Subject: Y/71/20/RES

Engineers Comments Regarding Surface Water Drainage

Reserved Matters Comments

Job Title			
LAND AT STAKERS FARM, YAPTON			
Drawing Title			
HIGHWAY CONSTRUCTION DETAILS (SHEET 1 OF 2)			
Client			
DANDARA LIMITED (SOUTHERN)			
Scale	Date	Designed	
AS SHOWN @A1	SEP 2020	AK	
Drawn	Checked	Approved	
JK	AK	SW	
Job No	Drawing No	Rev	
19-156	YAP-180-035	T2

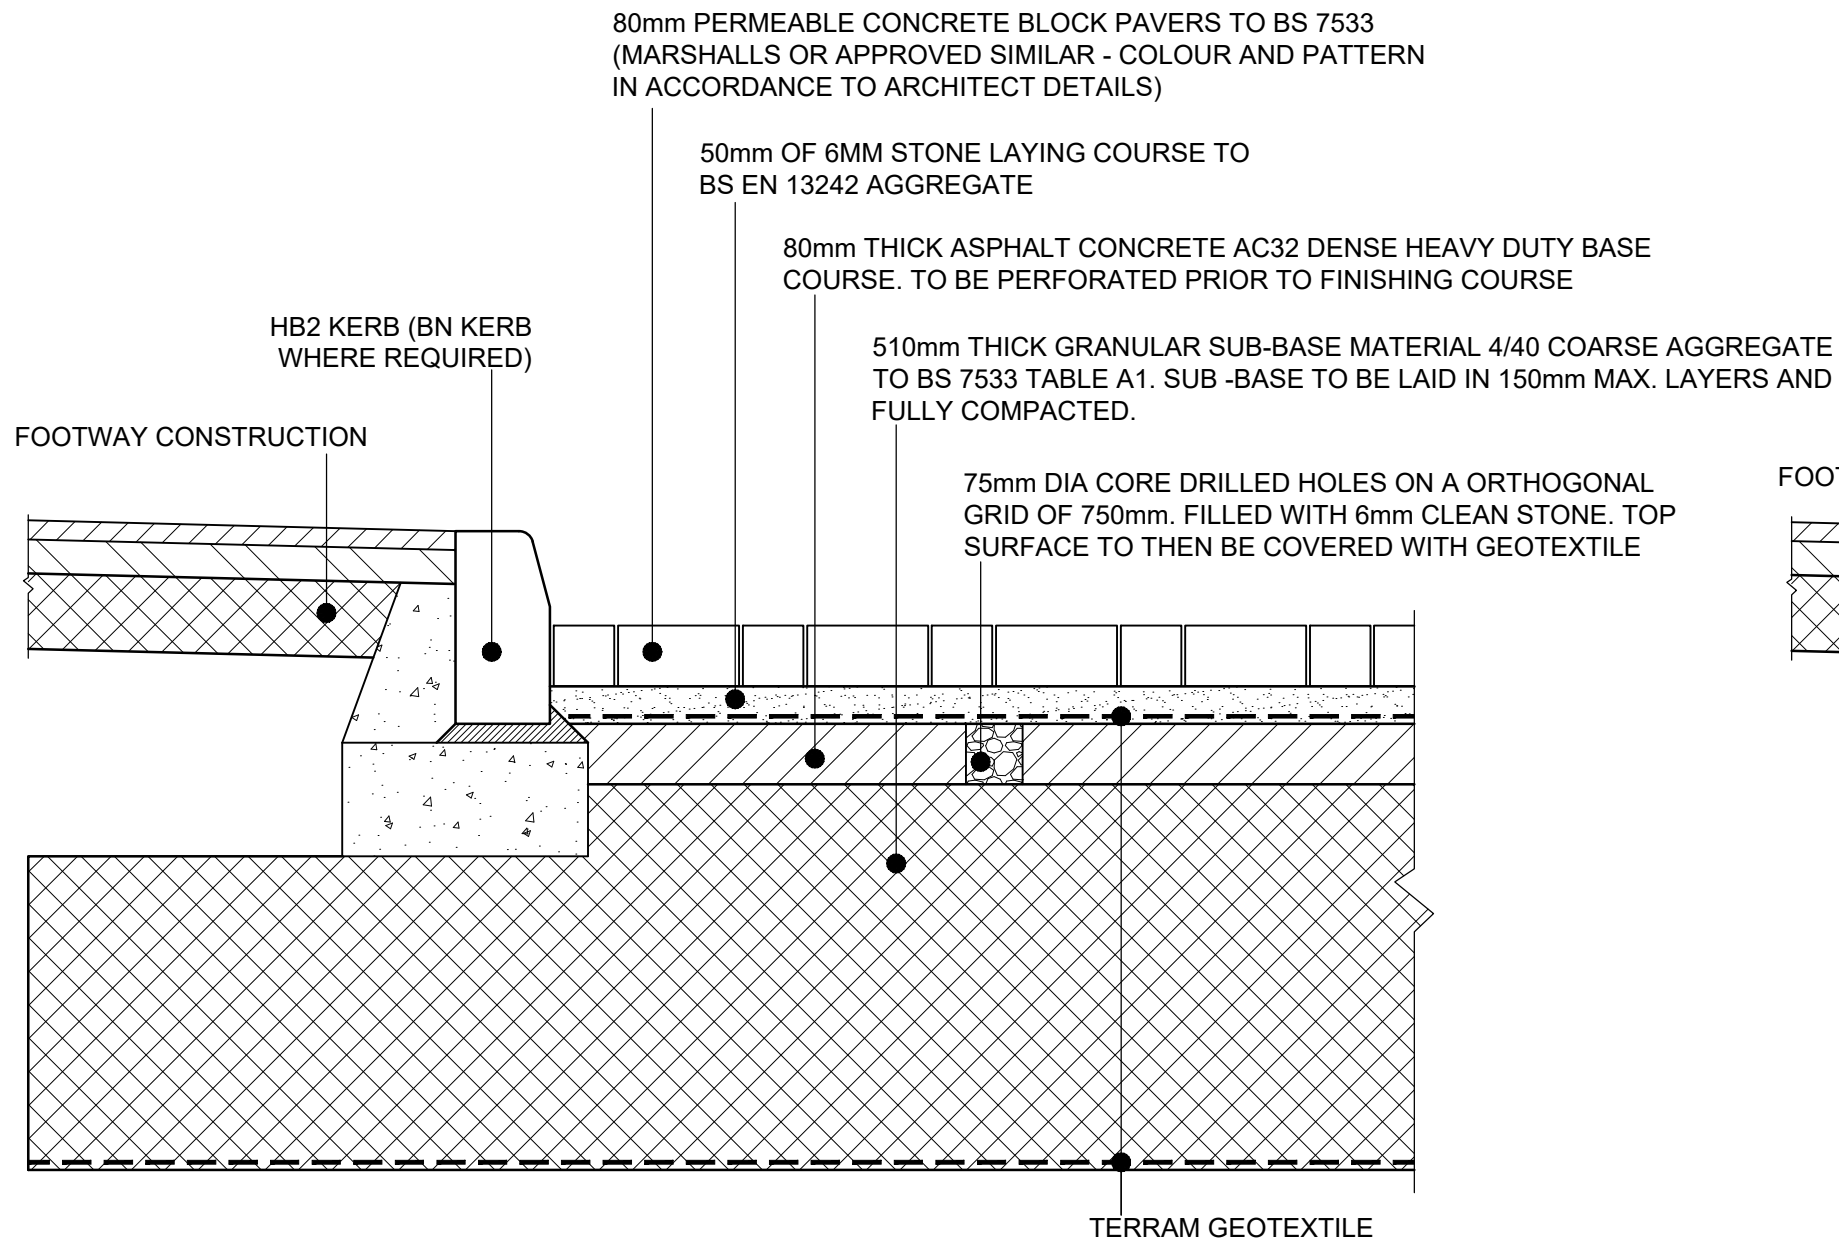
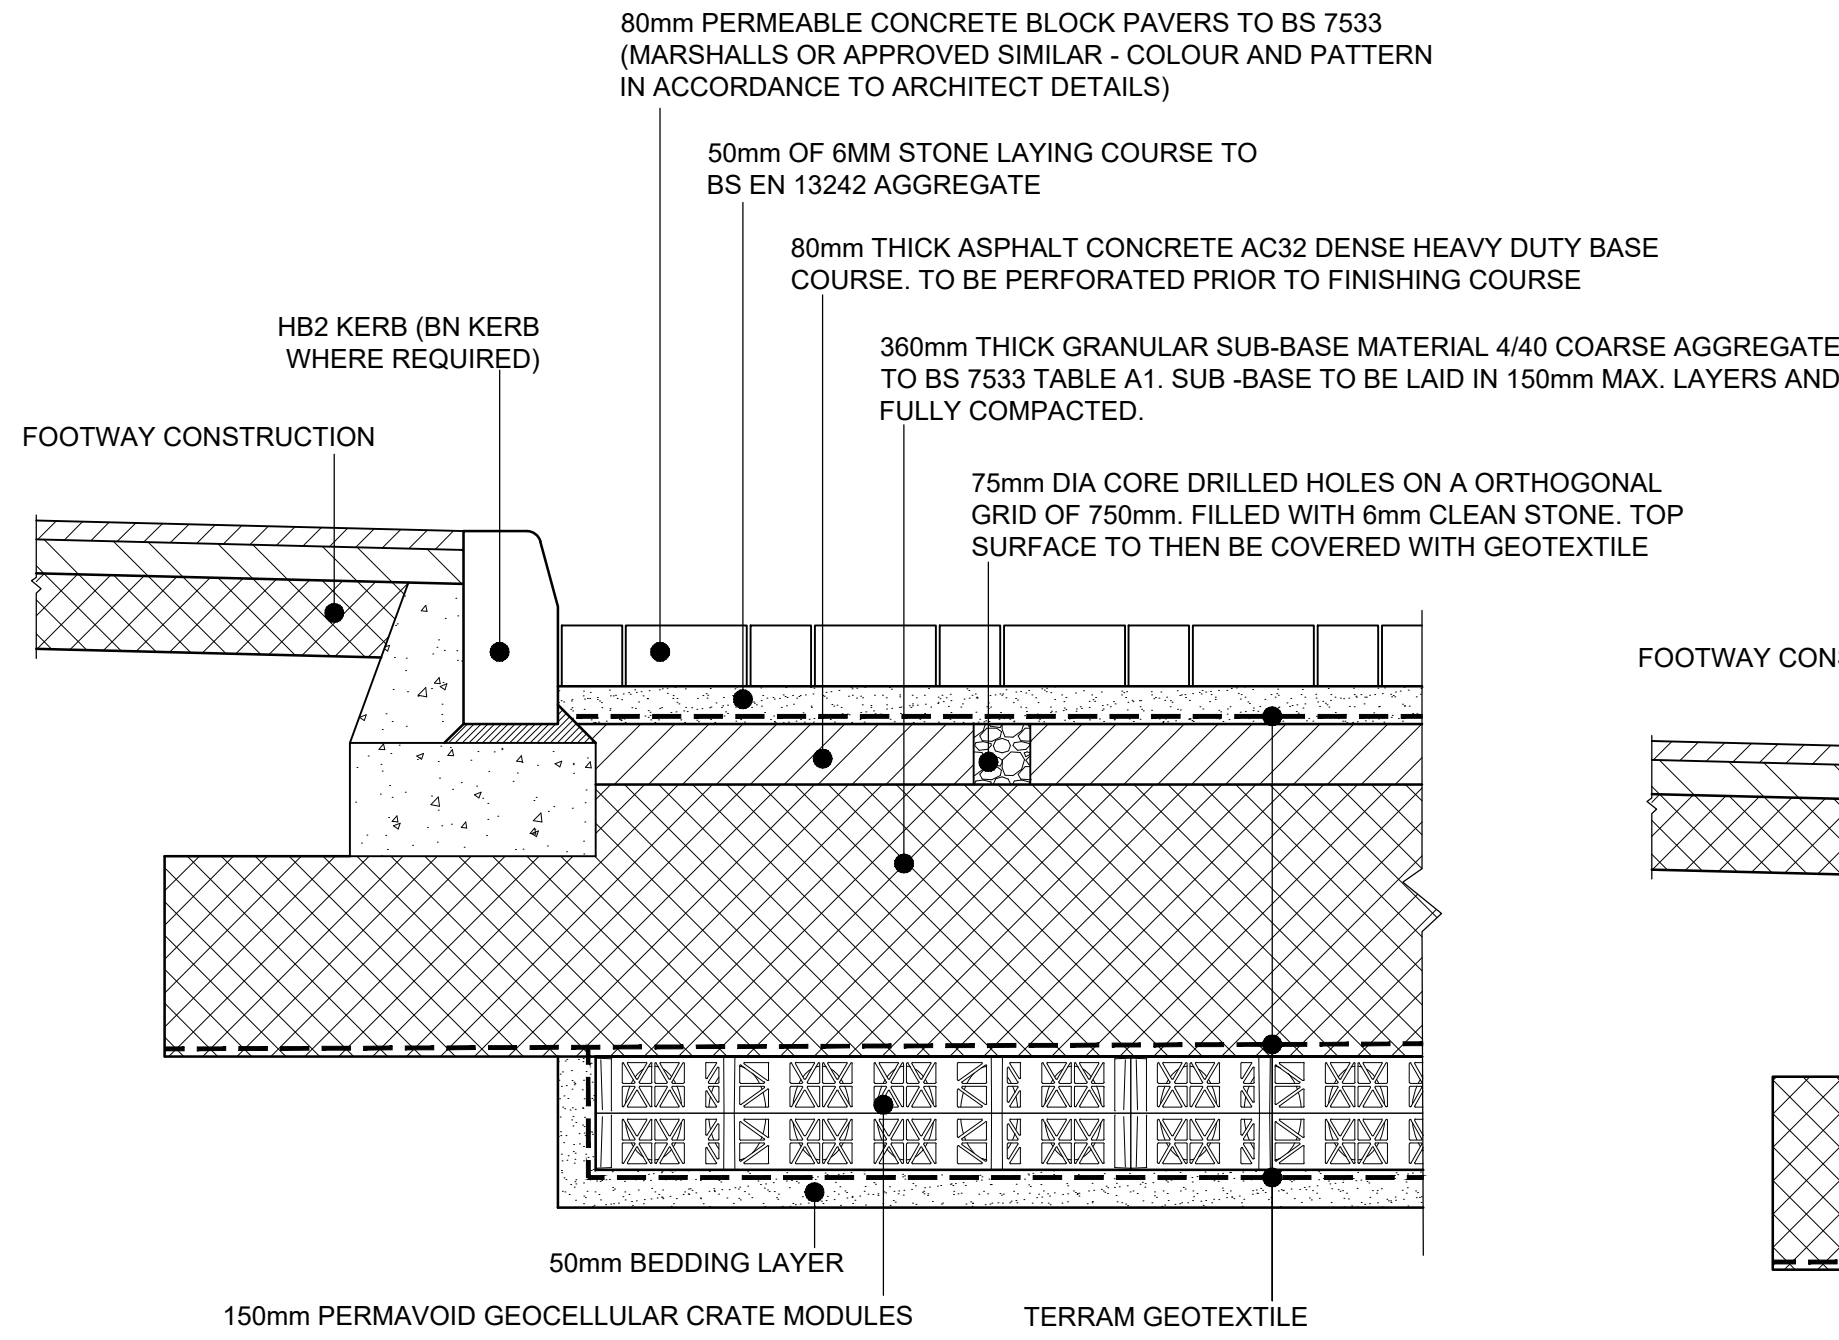
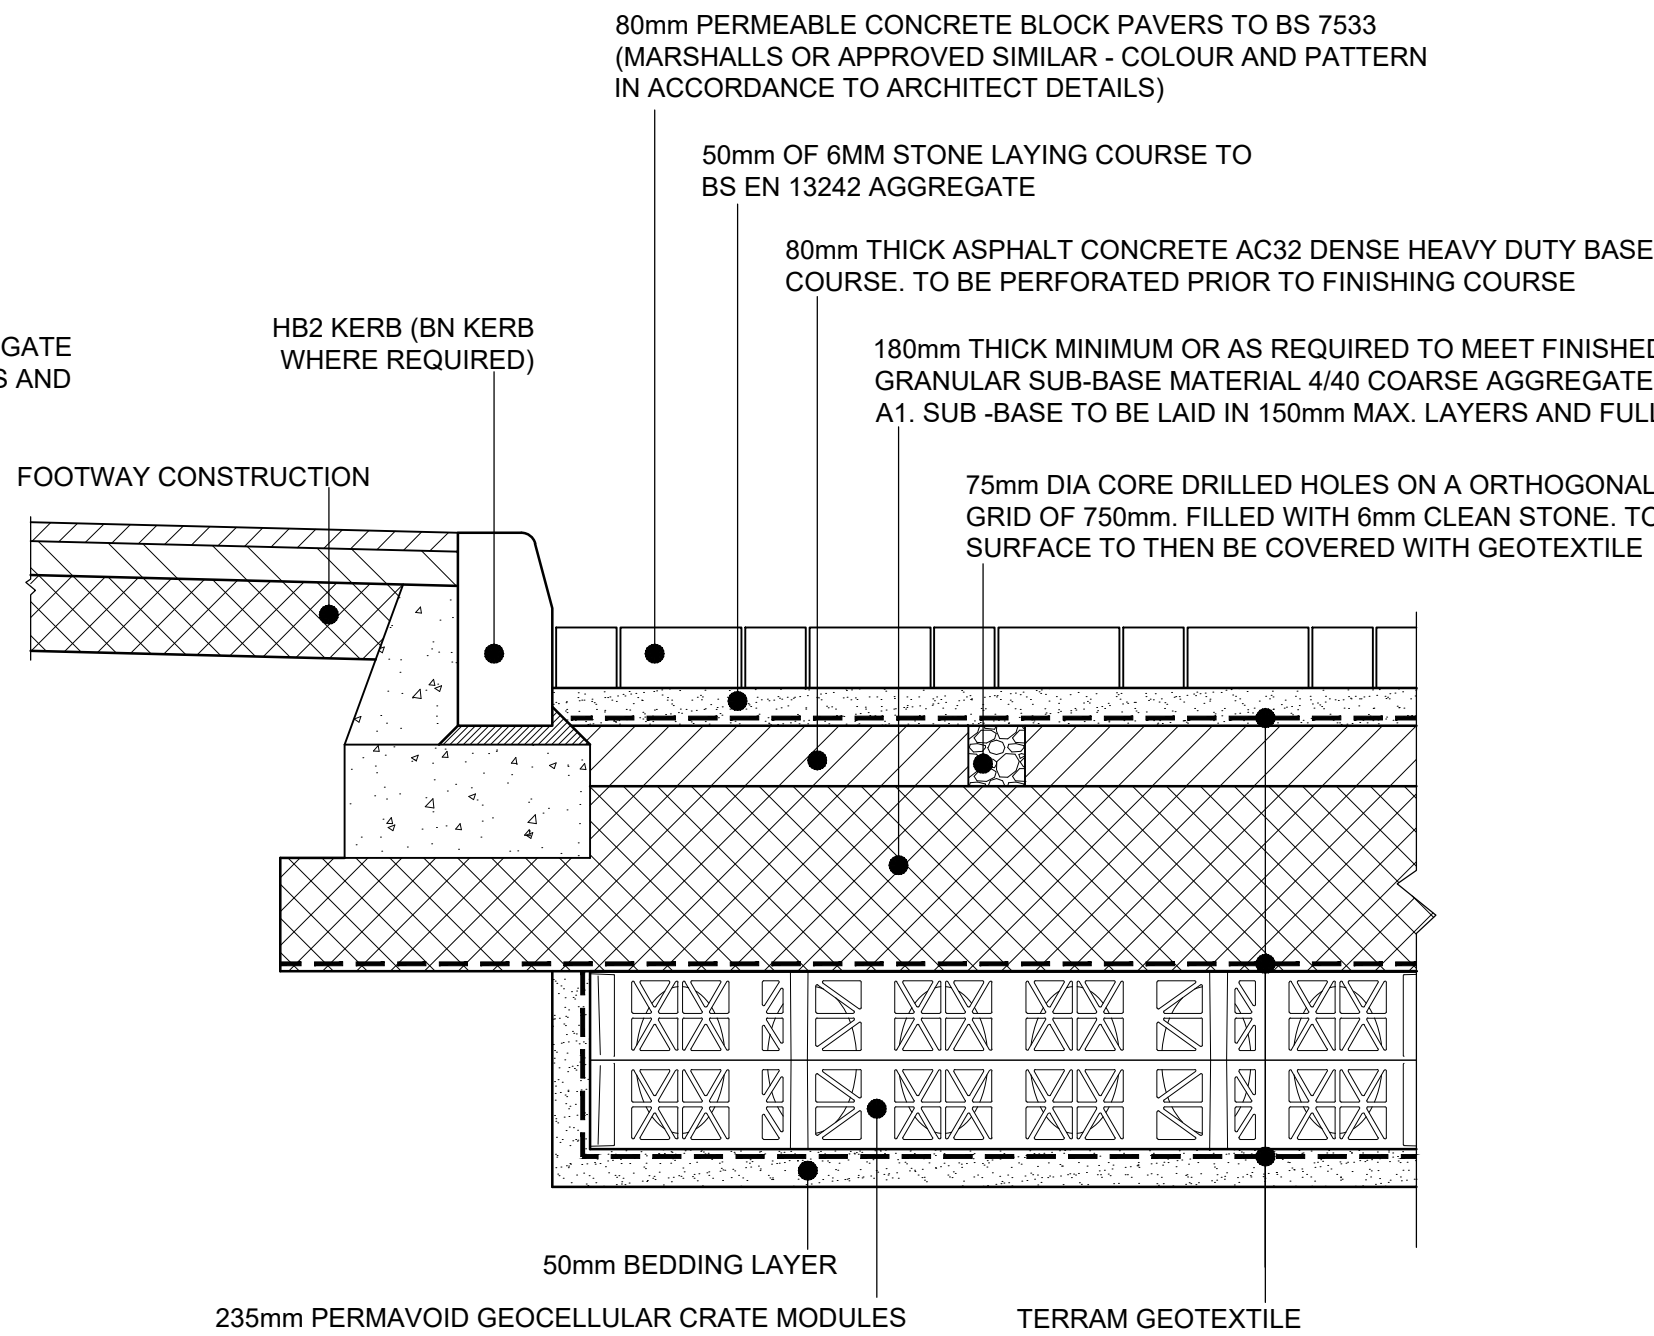
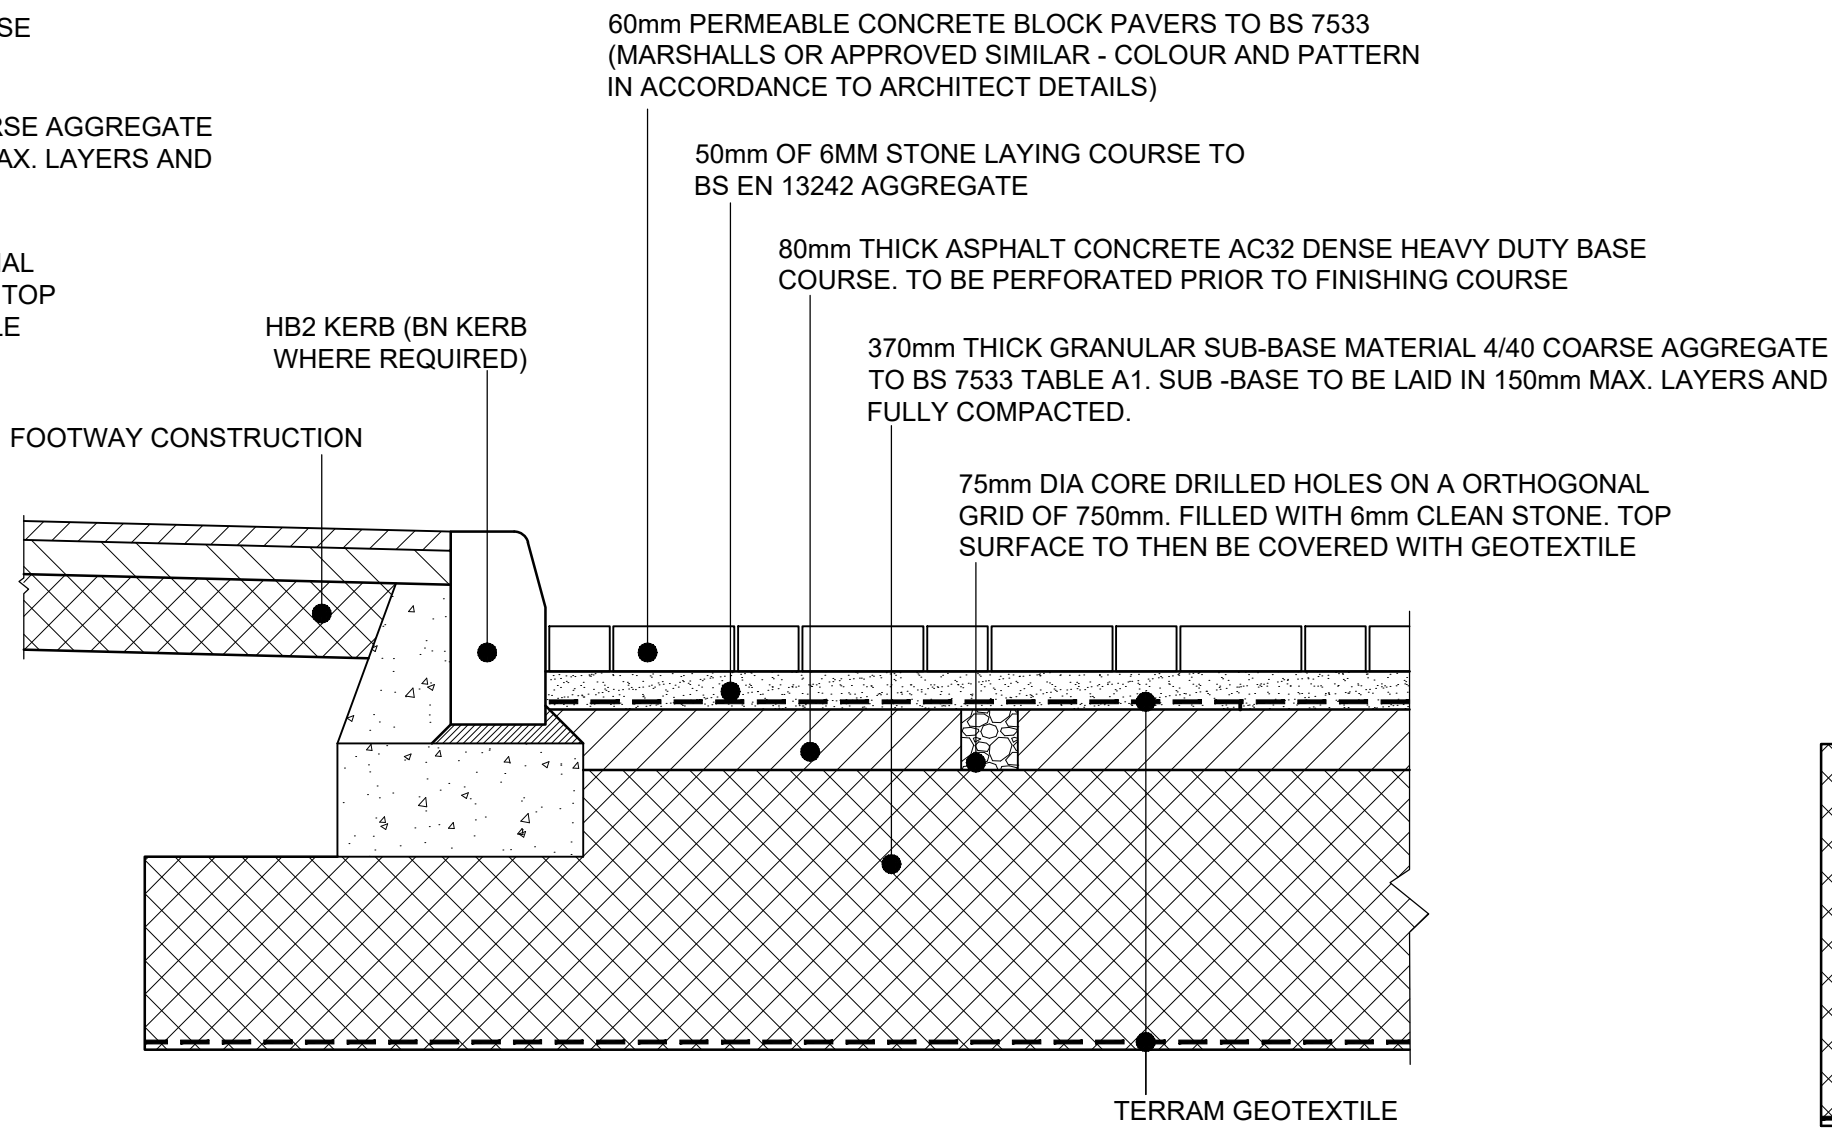
3. Within the checklist it is stated that all infiltration devices are kept to a maximum of 600mm depth. Yet permeable paving area 1 has a total depth of 770mm, permeable paving area 2 has a total depth of 710mm,

permeable paving area 3 has a total depth of 780mm, permeable paving area 4 has a total depth of 860mm. Please review or provide evidence that all features are located above peak recorded groundwater level, i.e. put groundwater levels on the drainage plan.

4. It is understood that the permeable paving areas will not have a flat sub-base, please provide spot levels on the drainage layout showing finish and formation levels of permeable paving.
5. Construction detail drawings of check dams have been provided, please clearly indicate on plan where these are proposed.
6. Please provide impermeable areas plans that clearly show the areas draining to each surface water drainage feature. Preferably provide these in dwg to facilitate paperless review.
7. Please provide network calculations.
8. A full review of calculations will be completed once this information is supplied.
